Subject: Public Facilities Application (File PF-18-00001) – Staff Review and Request for Additional Information

KITTITAS COUNTY
UPPER MAINTENANCE SHOP
SITE LAYOUT - CONCEPT D

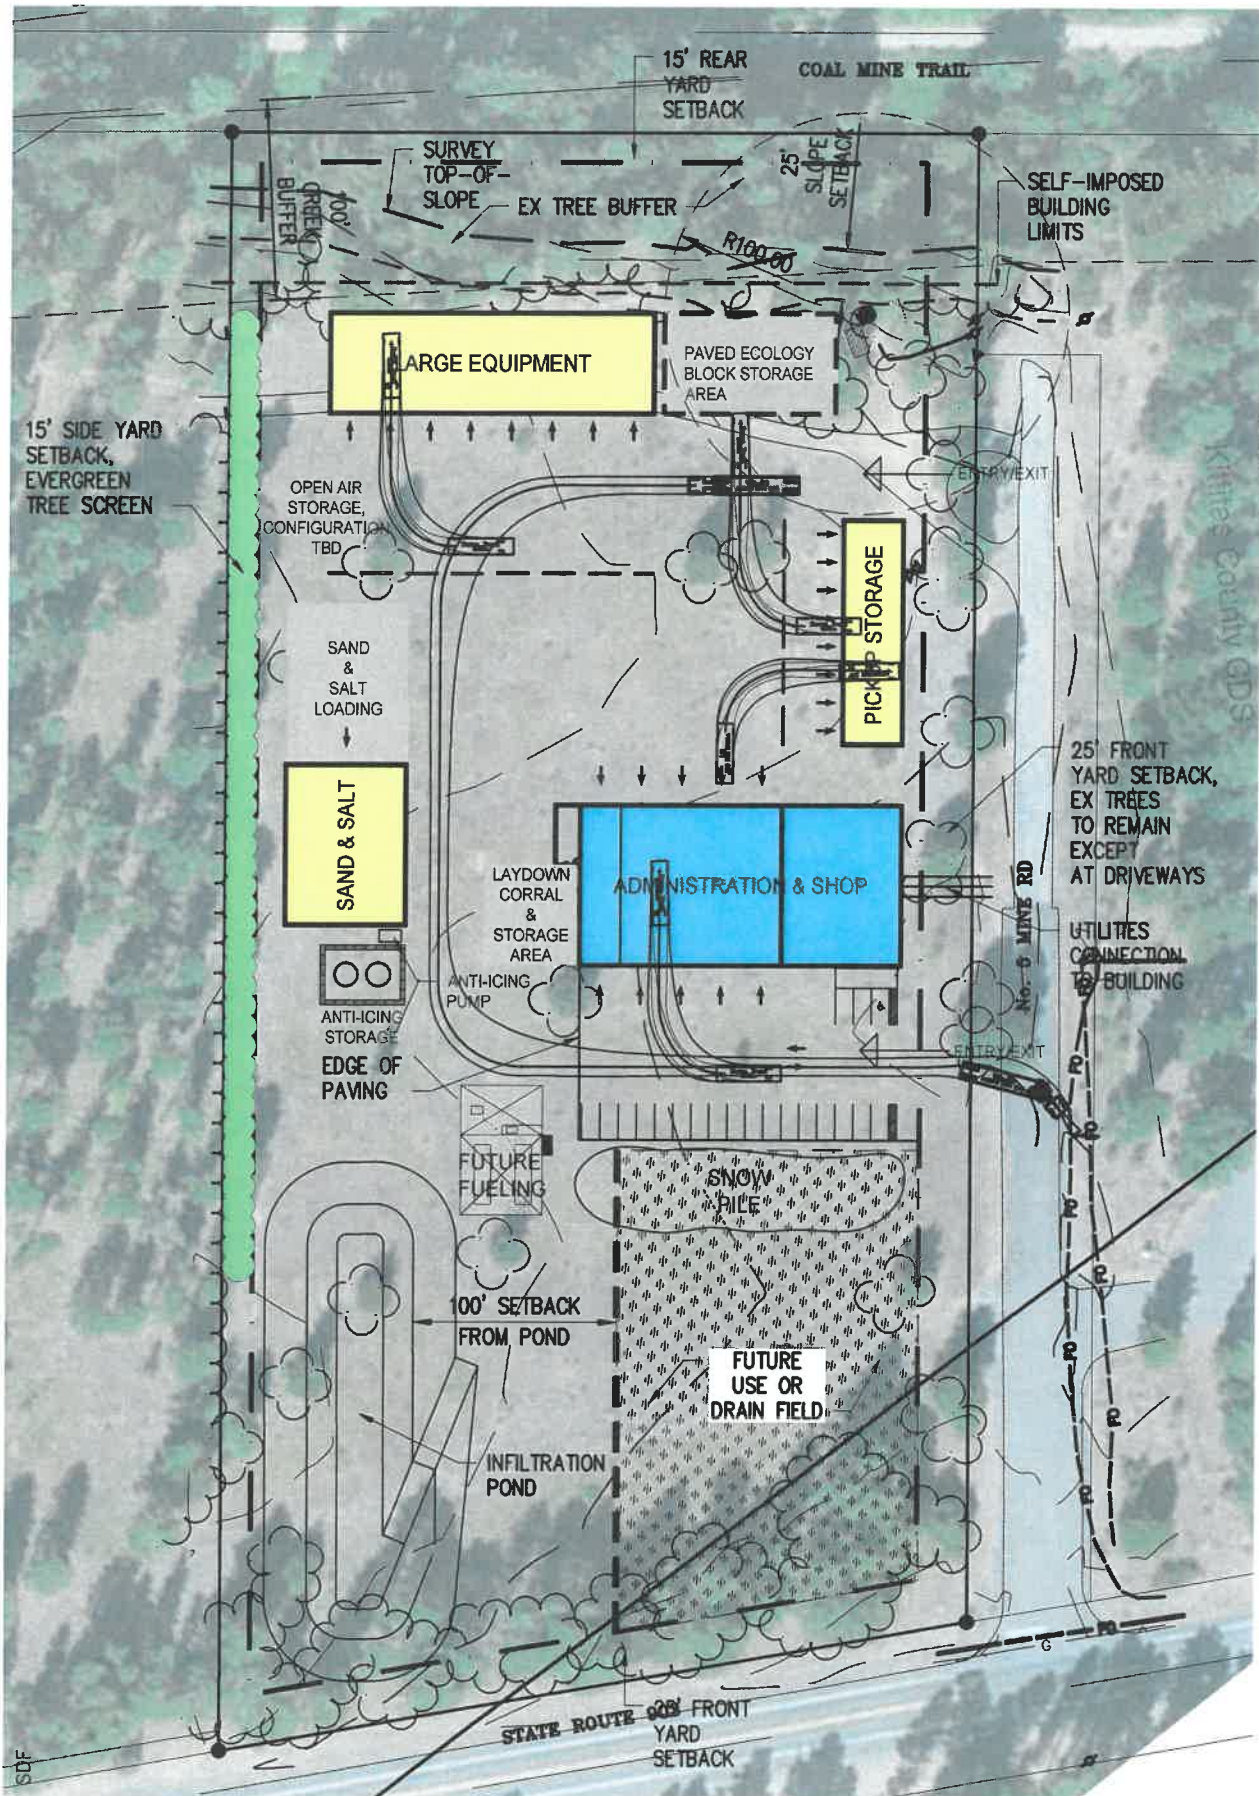
6. Please show fencing on your site plan.
